From: Richard Castro-Parker
Sent: 23 September 2019 12:11
To: Samantha Lee
Subject: RE: BE/139/18/PL - Innovation Centre Beeding Close

Please see the attached PDFs of the drainage layout plan for the site re: BE/139/18/PL - Innovation Centre Beeding Close. Please could you comment on these and whether they deal with the matters you have previously raised.

It has been drawn to my attention that further details regarding drainage at BE/139/18/PL - Innovation Centre Beeding Close had been sent to Stuart Corbey a while back and then to me 24 June. Please see the attached Drainage Strategy re: BE/139/18/PL - Innovation Centre Beeding Close. Additionally, It has been drawn to my attention today (24/07/2019) that the B2 building has already been built and that the agent/applicant feels that:

- Proposed Drainage Layout – 1:100 Scale;
- Proposed Drainage Layout – 1:400 Scale.

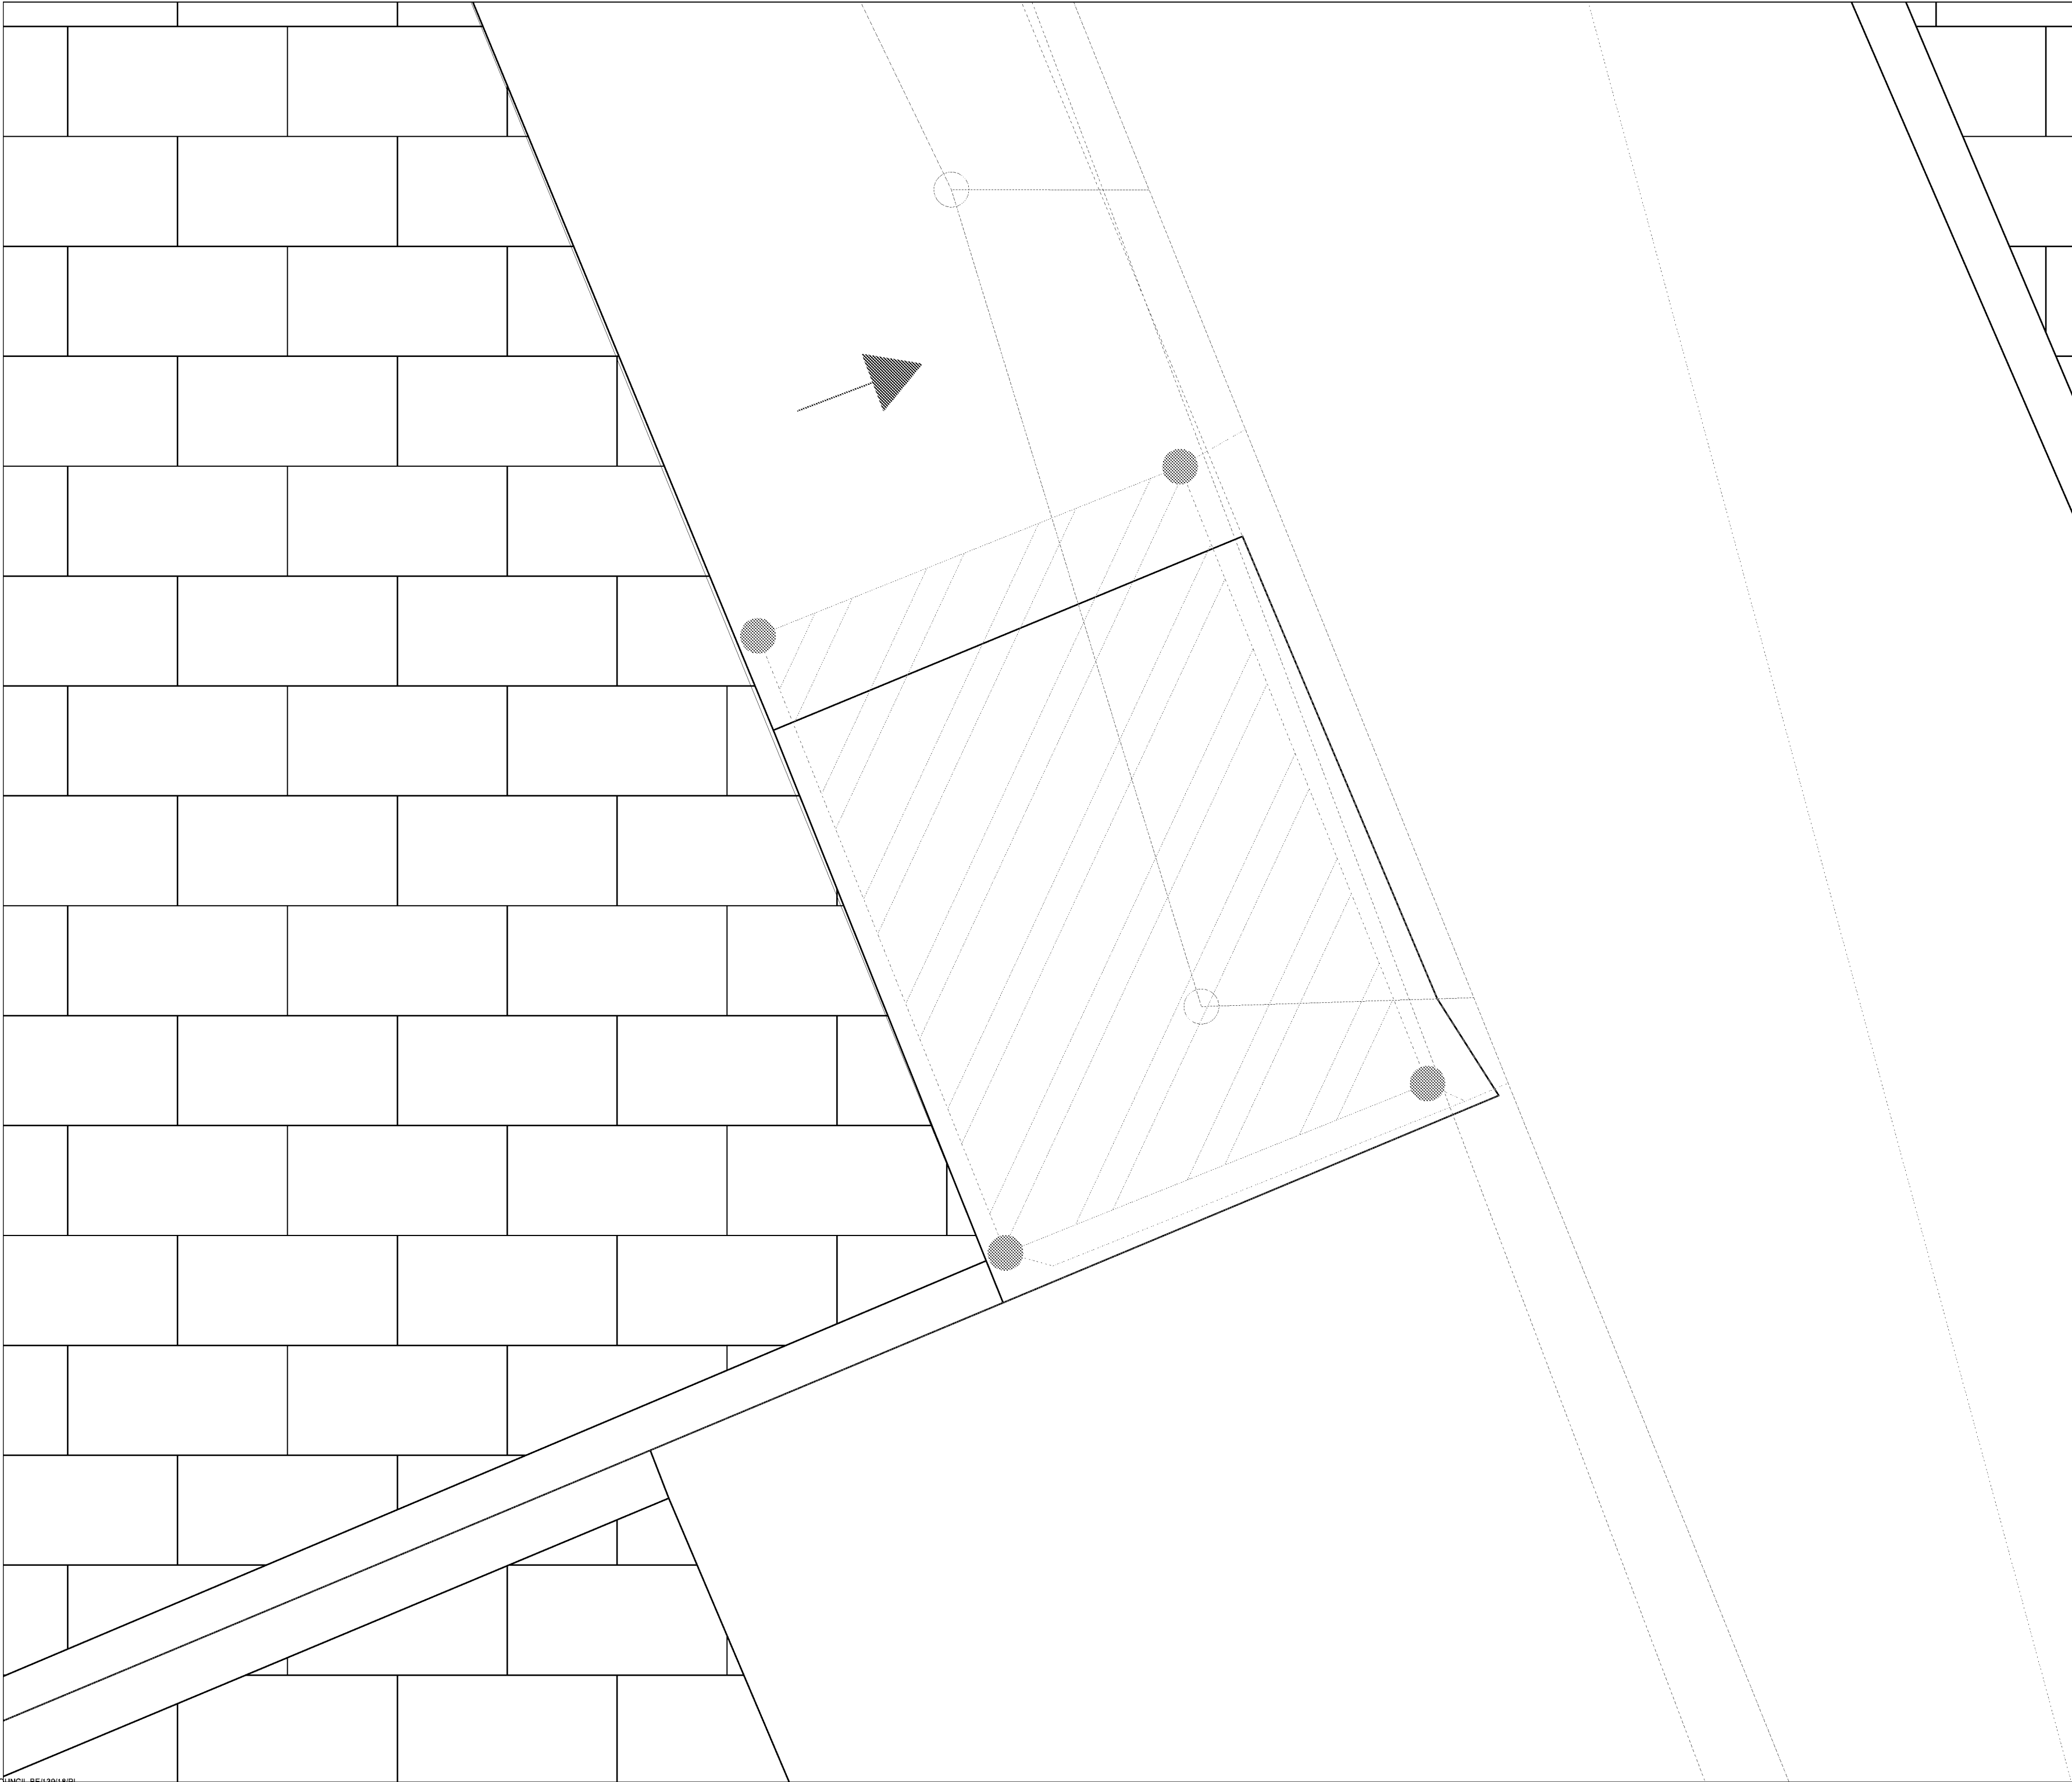
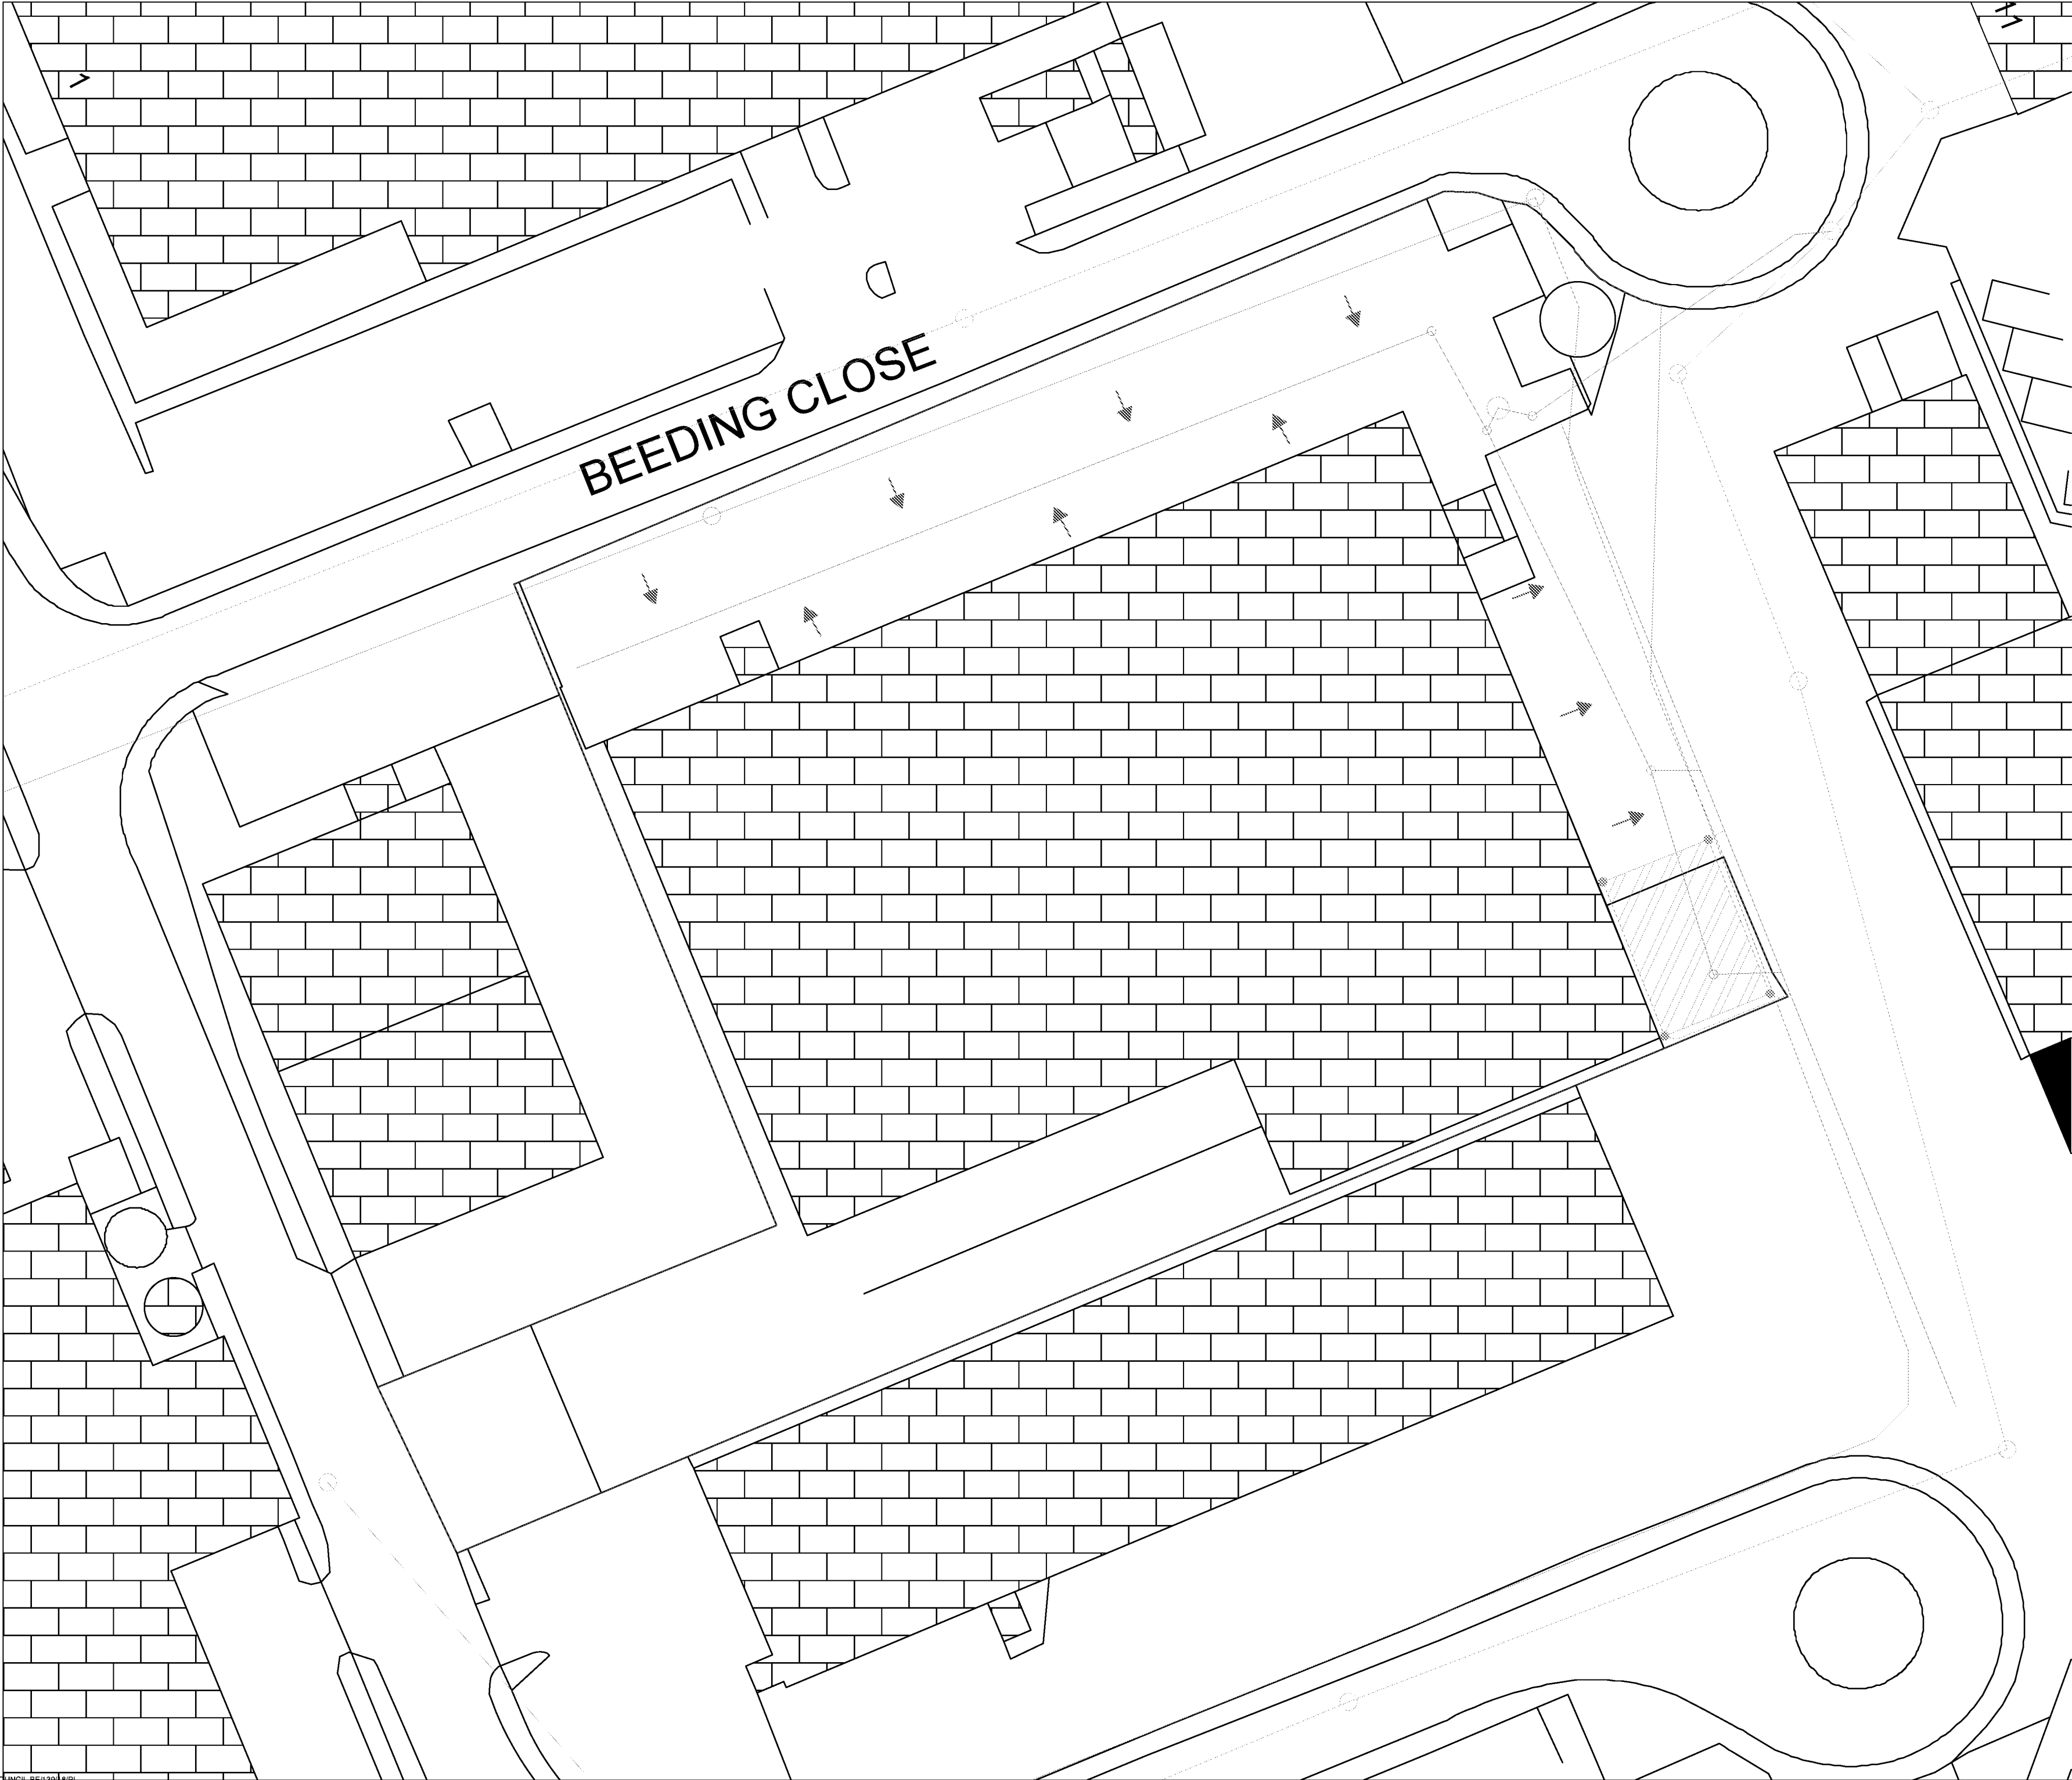
I still am struggling to distinguish between lines. Please can different line types be used, rather than all very similar colours. Please can gullies, manholes, and linear drainage channels be clearly labelled.

Regarding the levels, I also requested some spot levels of the surrounding land, can these be provided. This is fundamental to ensure that the surface water from the development does not go off site.

Please can the applicant submit clearer plans of the proposed surface water drainage arrangement. I.e. different line types used, rather than all very similar colours. Please can gullies, manholes, and linear drainage channels be clearly labelled.

I also require levels to be submitted showing invert and cover levels of the existing drainage network and spot levels of the surrounding land. This is fundamental to ensure that the surface water from the development does not go off site.

The colour of the lines have been changed and it is very different from each other in my screen. Please therefore let me know if Laura is still unable to distinguish them. I've also got confirmation from the client that they already have someone booked in to have the drainage cleaned.

With regard to spot levels, could Laura ascertain whether the Environment Agency LiDAR information would be sufficient information to determine the rough elevation of the surrounding land? Unfortunately, our flood consultant is not qualified to undertake a topographical survey of the surrounding land. We will therefore have to appoint a surveyor separately just to do the full survey for the displacement of 150sq.m of roof water.

Please find attached a PDF of the drainage layout plan for the site. Given the size of the site, all lines on the plans are small. However, if Laura zooms in she will be able to distinguish between the pipes types. This should hopefully address her first concern.

With regards to levels, having reviewed the sewer asset location search requested from Southern Water, both invert and cover levels for all Southern Water manholes are detailed within their response. A copy of the sewer asset location search was included within the appendix of the Surface Water Drainage Strategy – this have been attached to this email for her reference.
